DOC21/968110
MP08_0150-PA-46

Bulli Seam Operations - Appin Mine LWs 709-711 and 905 Extraction Plan (MP08_0150-PA-46) – post approval assessment

I refer to your request on 28 October 2021 for comments from the Environment, Energy and Science Group (EES) seeking advice on the *Appin Mine Areas 7 and 9 Longwalls 709 to 711 and 905 Extraction Plan* dated October 2021 (Extraction Plan).

**Appin Area
7 and 9
Longwall 905 and
Longwalls 709-711
Monitoring Locations
Overview
Figure 2**

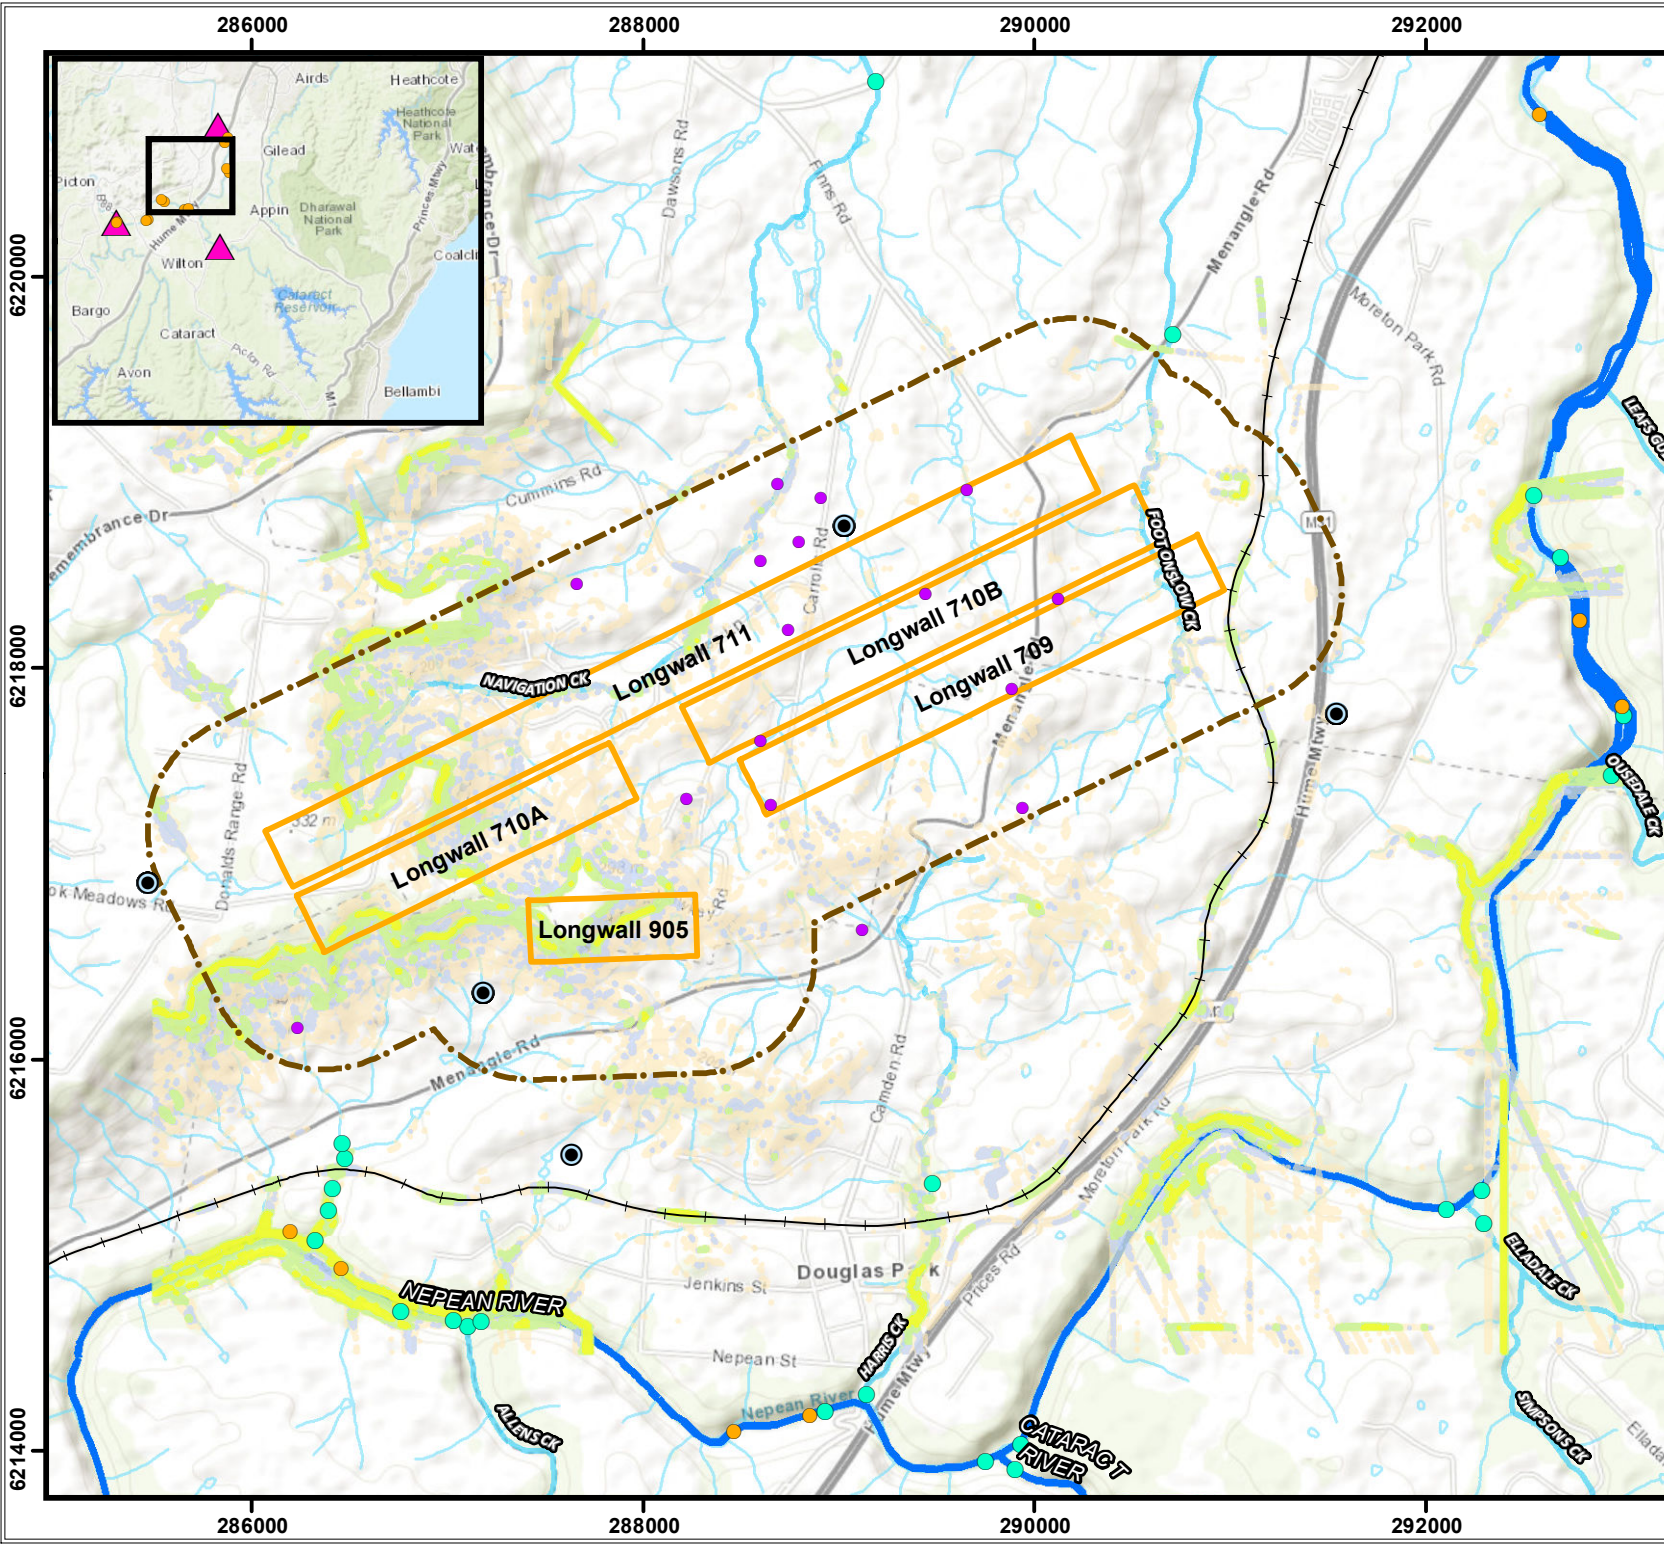
- There are no locations where water levels in **pools, alluvium or hard rock aquifers** are monitored directly above the proposed longwalls (see Figure 1).
